Application No: EP/124/20/HH
Site Address: Little Dormers 23 Upper Drive East Preston BN16 1QN
Description of works: New bay and porch skirt roof to the front elevation, and roof linked detached double garage.

Thank you for your internet representation made on 1st December 2020 which has been recorded as an objection with the comments as follows:

Drawing Name
Elevations-
Proposed

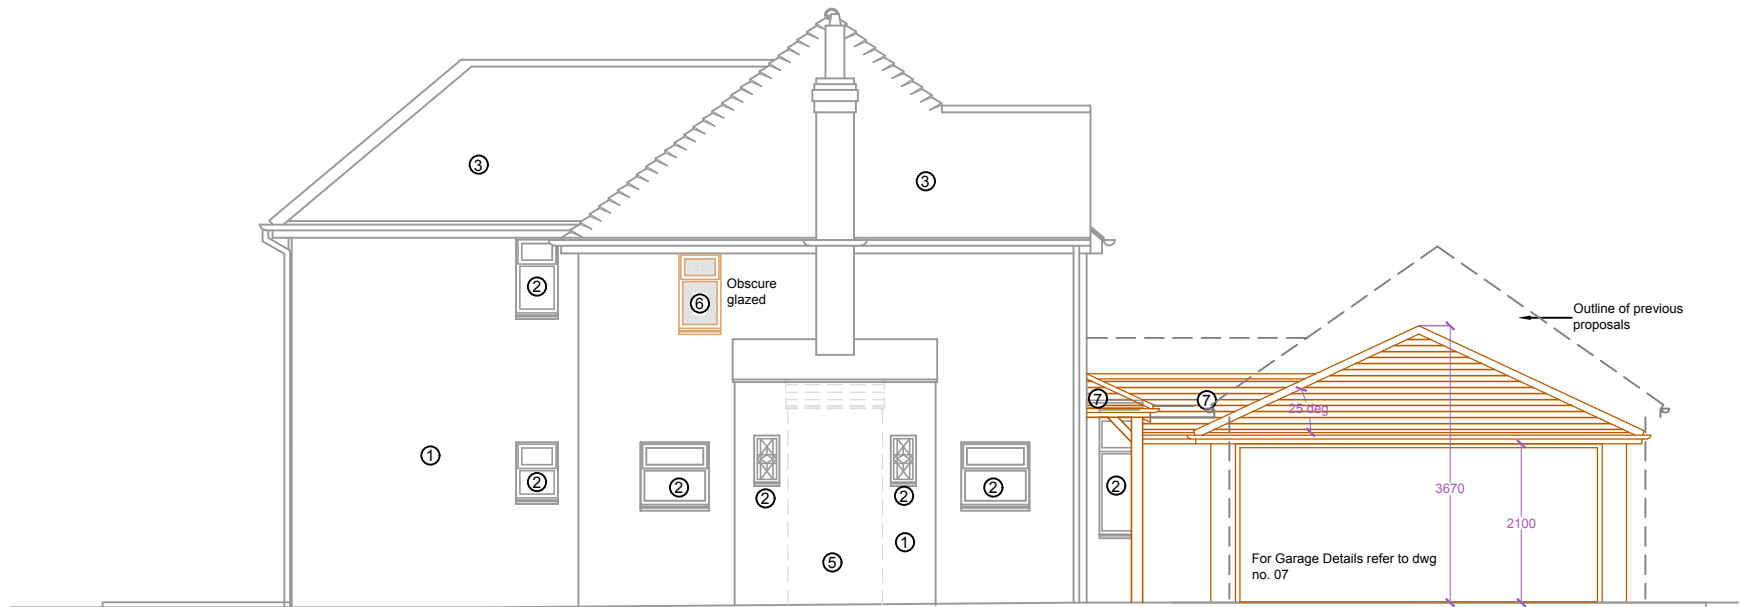
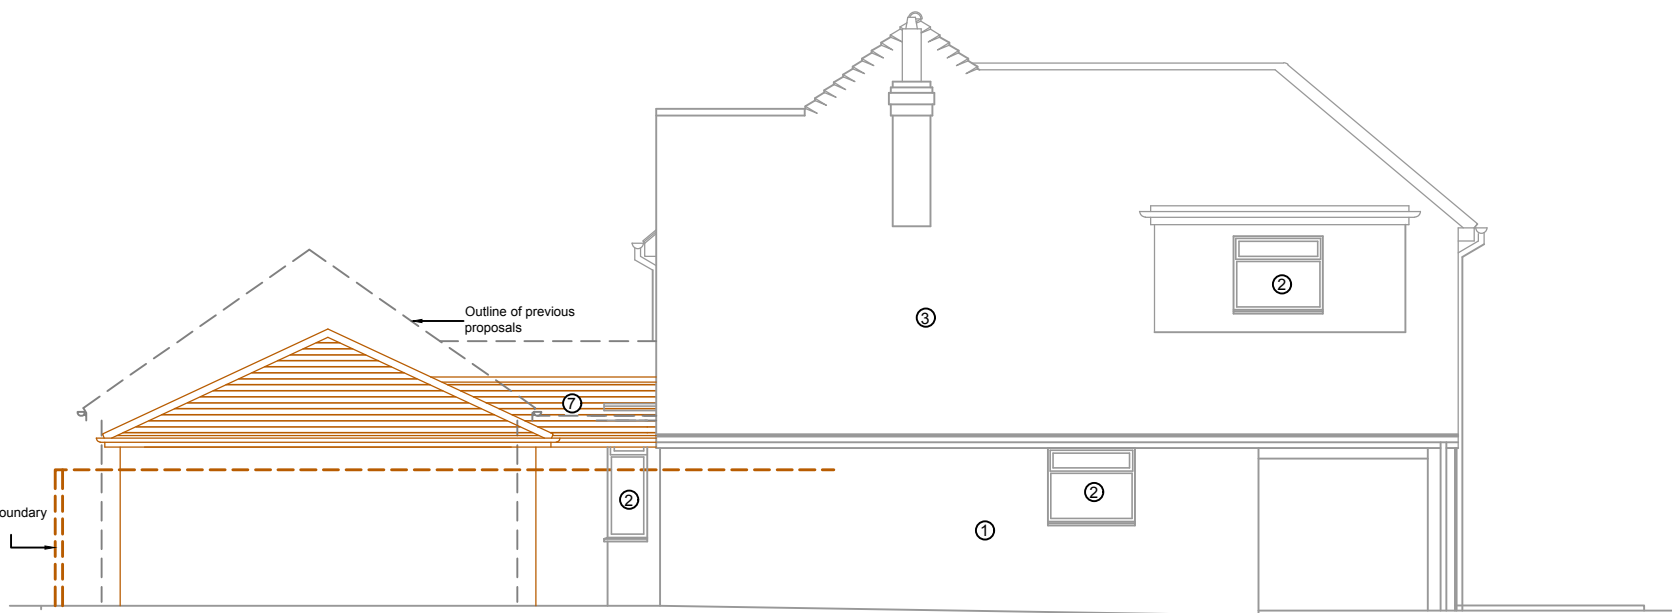
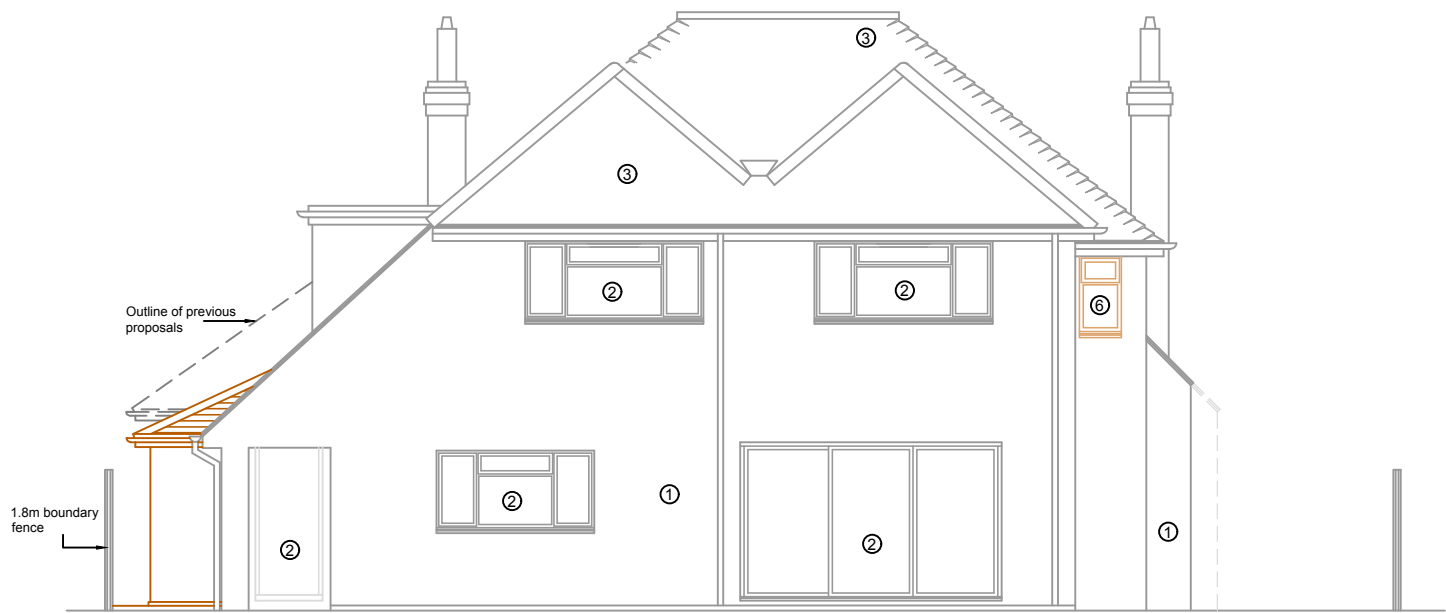
Following on from our objection logged yesterday. We understand that the application also includes two first floor windows which will over look our property. This will grant clear views into our downstairs bedroom and bathroom and first floor bedrooms.
